**Proposed Himley Village North West Bicester  
Middleton Stoney Road Bicester**

**23/00170/REM and  
23/00214/REM**

**Proposal:** Reserved Matters Application pursuant to outline planning permission 14/02121/OUT for Phase 1A (infrastructure comprising two junctions to provide vehicular and pedestrian access into the site from Middleton Stoney Road and two initial sections of internal road) along with the partial compliance of conditions 12 (Building for Life 12), 16 (means of vehicular access), 17 (means of pedestrian/cycle links) and 19 (detailed surface water drainage scheme) for Phase 1A.

TITLE MIDDLETON STONEY ROAD, MAIN SPINE ROAD JUNCTION. GENERAL ARRANGEMENT SHEET 1	
HYDROCK PROJECT NO. C-27141-C	SCALE @ A2 1 : 500
STATUS DESCRIPTION INFORMATION	STATUS S2
DRAWING NO. (PROJECT CODE-ORIGINATOR-ZONE-LEVEL-TYPE-ROLE-NUMBER) 27141-HYD-XX-XX-DR-D-0001	REVISION P02

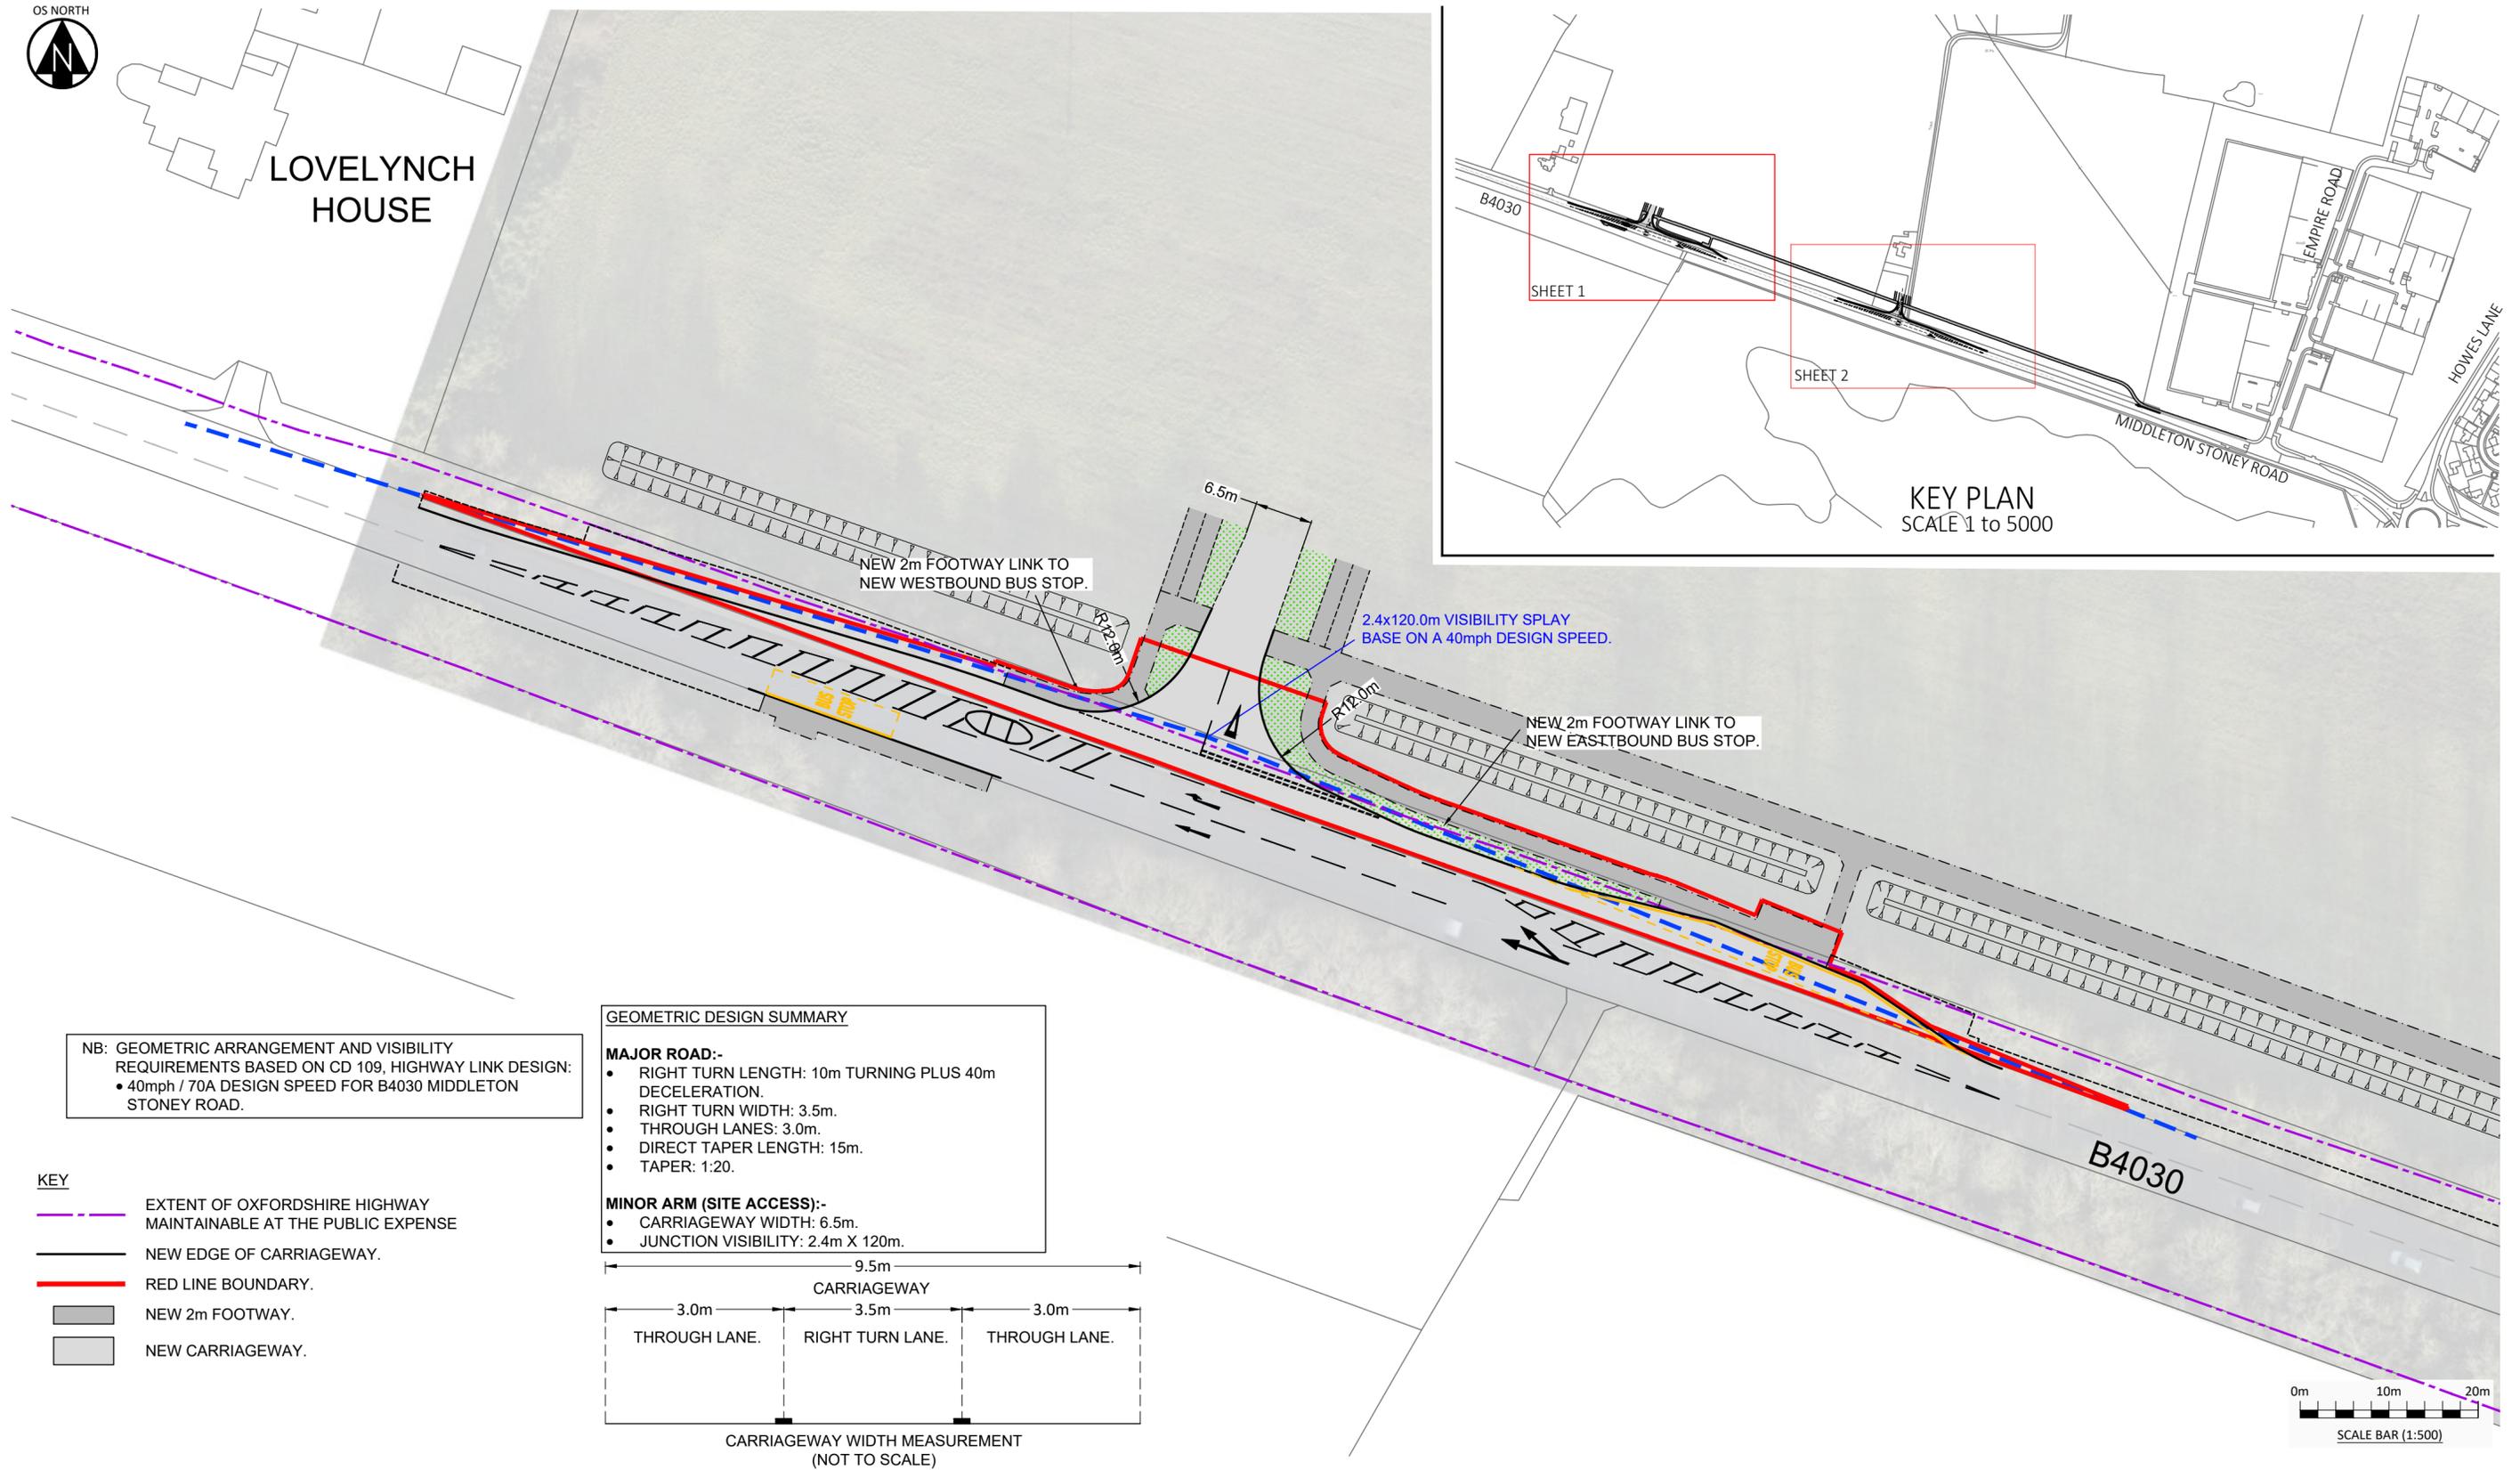
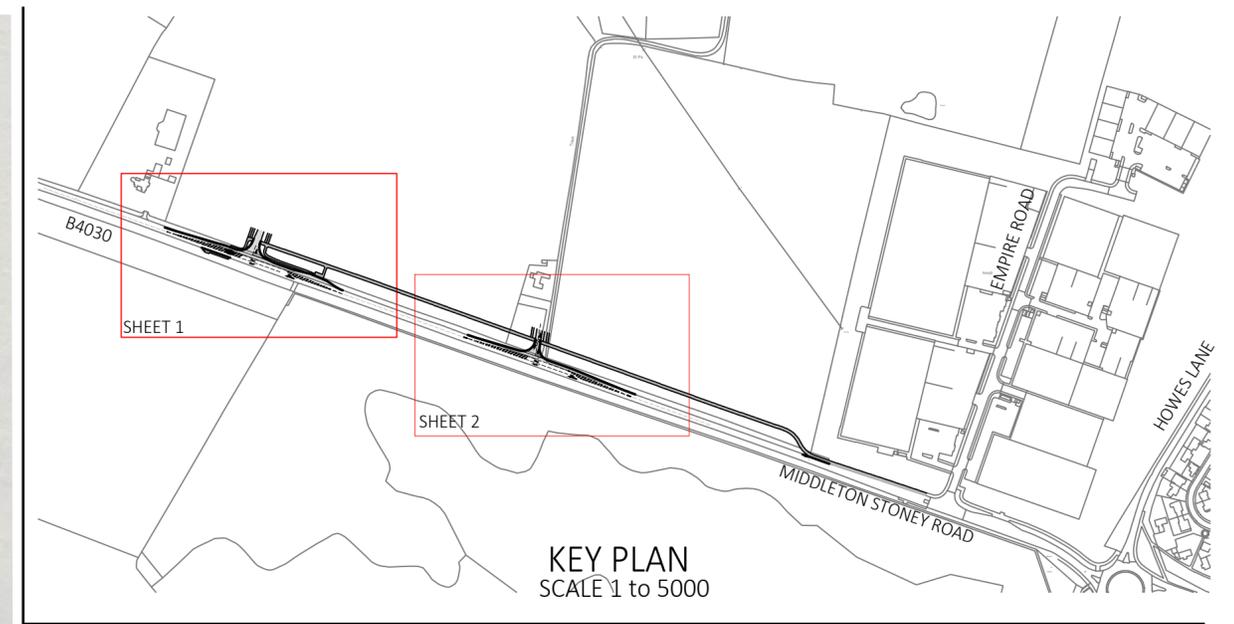
- 2) The proposed cycleway and footpath from Middleton Stoney to Bicester (required as part of the Heyford development) should be represented on the plans; AND
- 3) Traffic from the development should not be allowed to turn right towards Middleton Stoney due to overcapacity at the B4030/B430 junction in the village.

Make the following comments: Concern that the junctions show a cycle path on only one side of the spine road in conflict with OCC standards and uncontrolled crossings for cyclists and pedestrians at the junctions will not prioritise them as highway users. *[Officer Note: The outline planning permission was granted prior to LTN1/20 and the foot/cycle paths on the Middleton Stoney Road were agreed as part of the S106]*

*[Officer Note: Condition 30 of the outline requires the submission and approval of a routing agreement for construction traffic. The plans only need to detail provision within the red line site area and to demonstrate that the proposals can meet the S106 requirements of the outline permission. The traffic generation for the operational period has been assessed and considered acceptable as part of the outline permission and with no objections from OCC Highways there is no justification for routing restrictions for non-construction traffic leaving the site.]*

*agreement. The cycle and pedestrian paths along the spine road and the crossing facilities are all outside of these reserved matters applications (beyond the red line) and therefore subject to consideration under future reserved matters but additional information provided by the applicant demonstrates that they can comply with the current standards (i.e. segregated and on both sides).]*

- 8.6. Secondly, they state that the proposed cycleway and footpath from Middleton Stoney to Bicester (required as part of the Heyford development) should be represented on the plans. A more detailed plan has been provided by the applicants to show that footpath and cycle paths will be provided for this development along the Middleton Stoney Road to connect it to proposed and existing bus stops in accordance with Schedule 18 of the S106 for the outline permission. This is considered to be appropriate for these planning applications and requirements of other planning permissions schemes cannot reasonably be applied to this proposal.

TITLE  
MIDDLETON STONEY ROAD,  
SECONDARY ROAD JUNCTION.  
GENERAL ARRANGEMENT  
SHEET 2

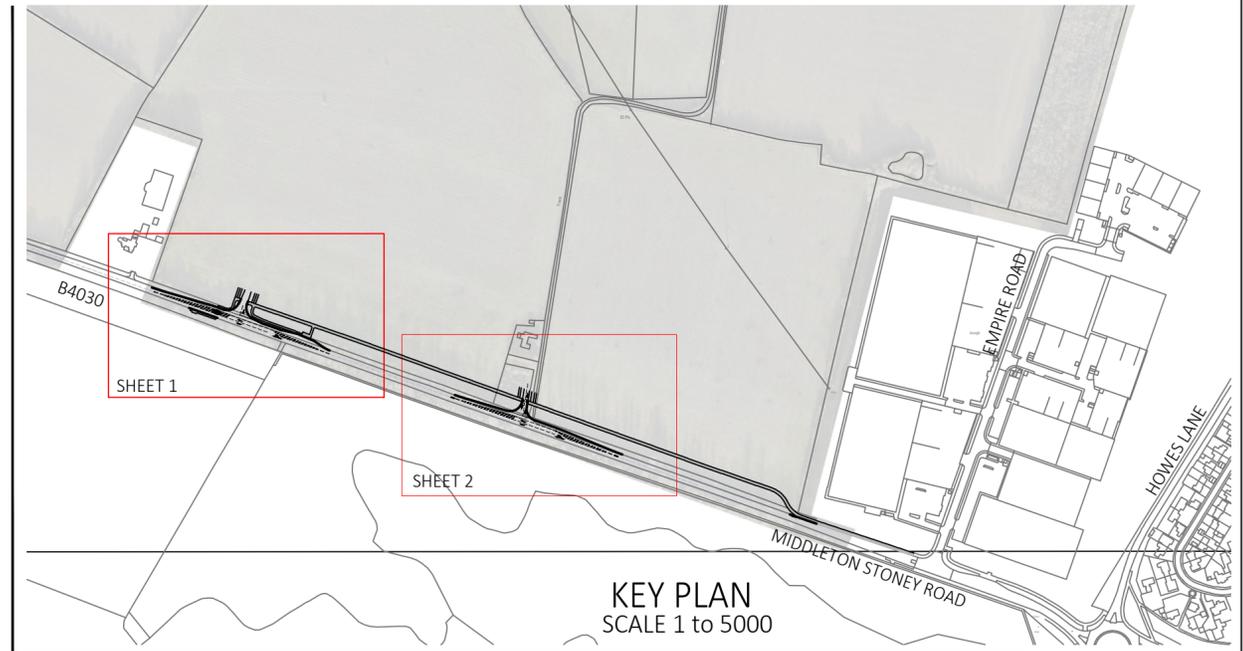
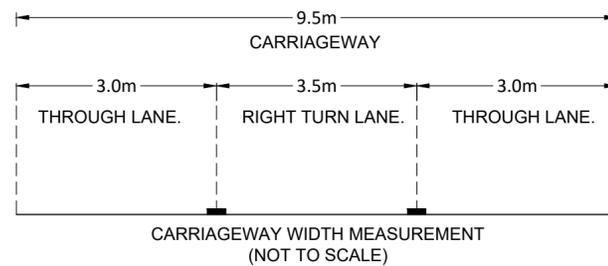
Local Highways – No objection. They originally objected to the application on the grounds that the secondary access was not sufficiently wide to allow 2 buses to pass. They have subsequently removed this objection on the grounds that the bus service would not need to use the secondary road/access even for a temporary period and that adequate public transport provision could be achieved for an interim period from the service on Middleton Stoney Road prior to buses entering the site via the primary access road and the adjoining Axis J9 development. Confirm that they have no objections relating to partial compliance with conditions 16 and 17.

TITLE  
MIDDLETON STONEY ROAD,  
MAIN SPINE ROAD JUNCTION.  
PROPOSED DRAINAGE  
SHEET 1

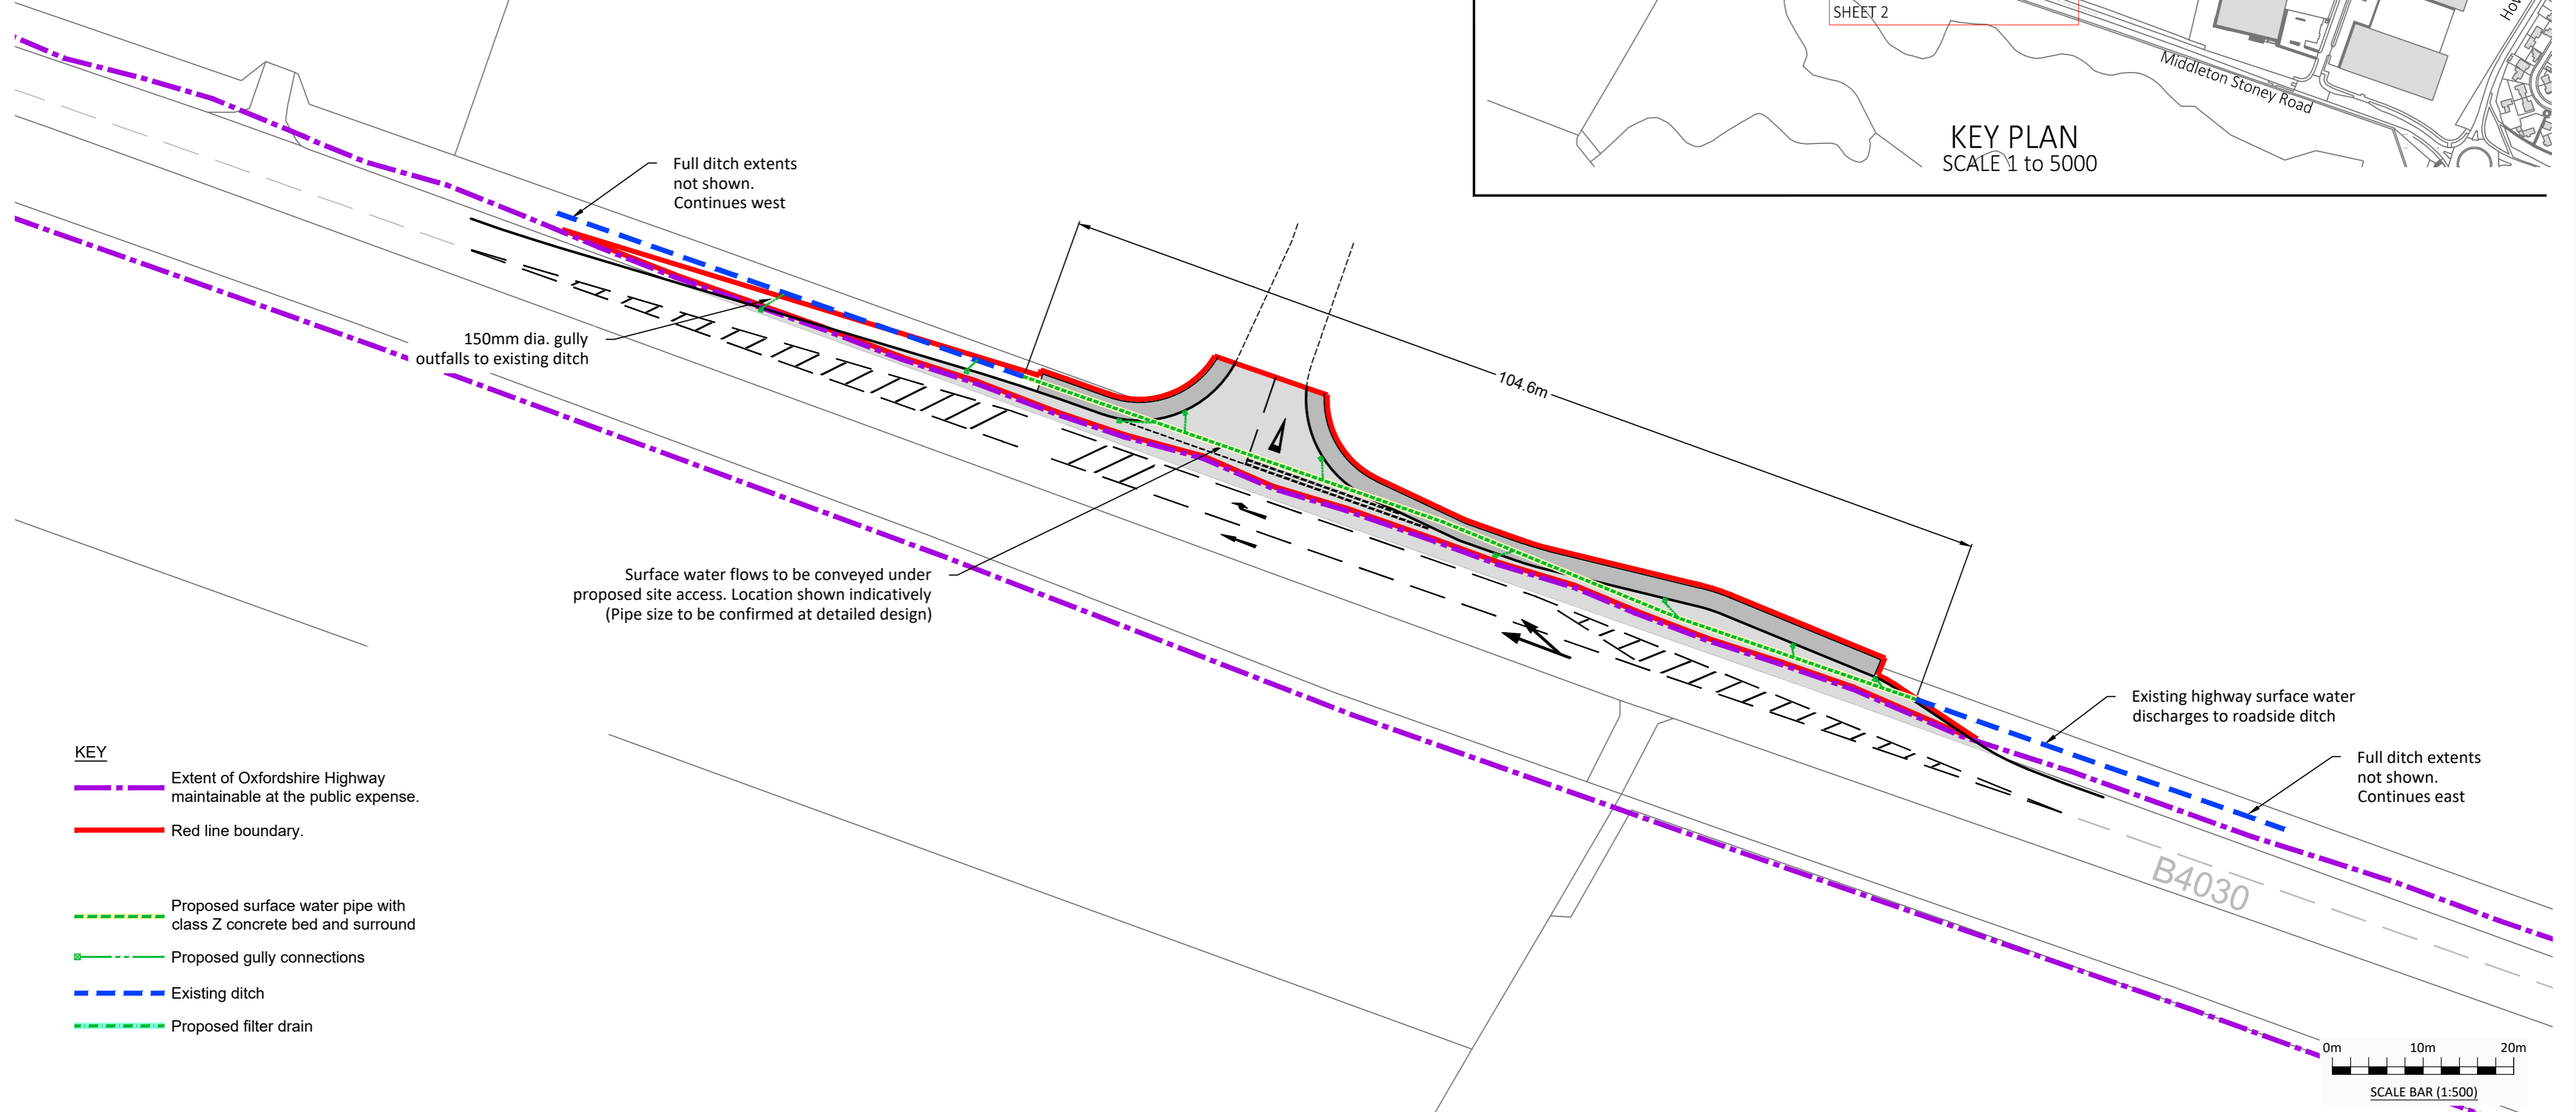
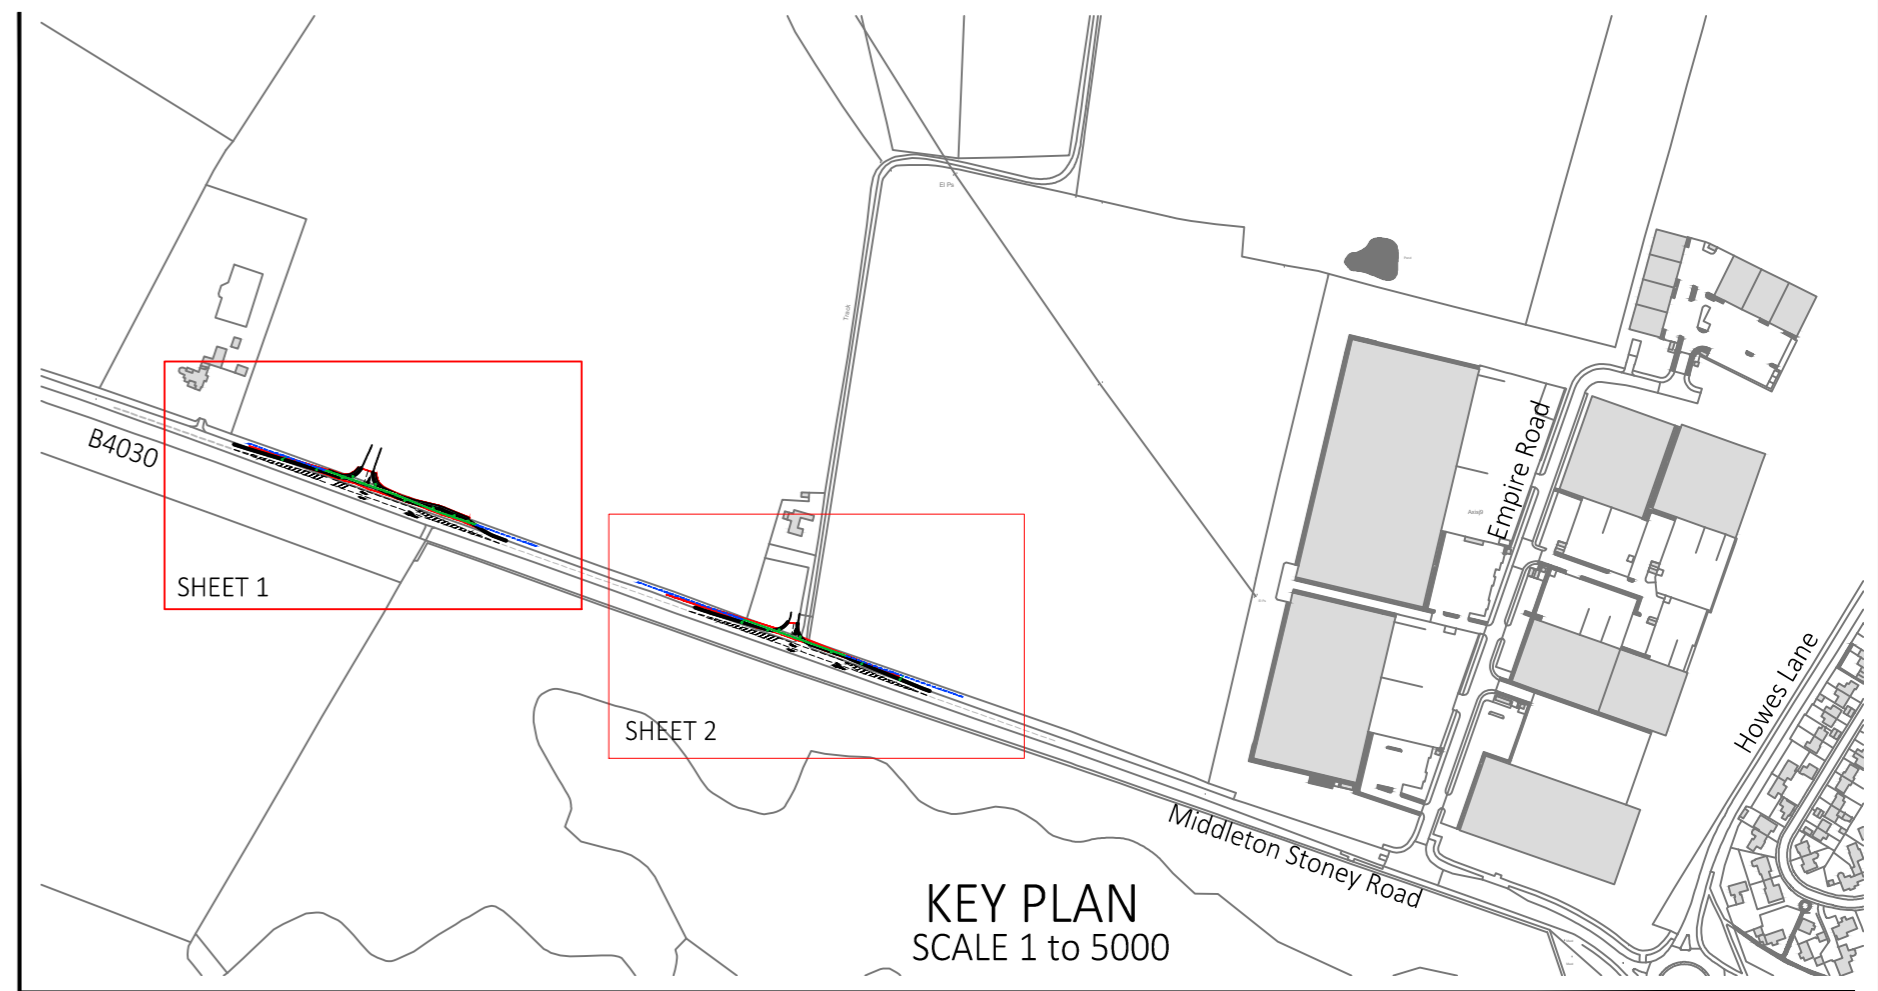
Lead Local Flood Authority – No comments but observe that condition 11 of the outline permission will need to be discharged. They confirm that they are content with the submitted Phase 1 drainage strategy which relates to the partial compliance with condition 19 *[Officer Note: Condition 11 was discharged under ref: 23/00207/DISC]*.

- 8.15. The LLFA have not raised any concerns about these applications but observe that Condition 11 (Site Wide Surface Drainage Scheme) would need to be discharged. However, in addition to the SWDS, Condition 19 requires each reserved matters for a phase to be accompanied by a detailed surface water drainage scheme for that phase, to meet the flood risk, water quality, green infrastructure and biodiversity requirements of the site. The detailed surface water drainage scheme should be in compliance with the approved Flood Risk Assessment, Surface Water Drainage Strategy and the Masterplan Surface Water Drainage Strategy and the approved site wide detailed surface water drainage strategy required under condition 11. The LLFA are satisfied with the detailed Phase 1 drainage strategy as set out in the Tech Note provided 22 March 2023.
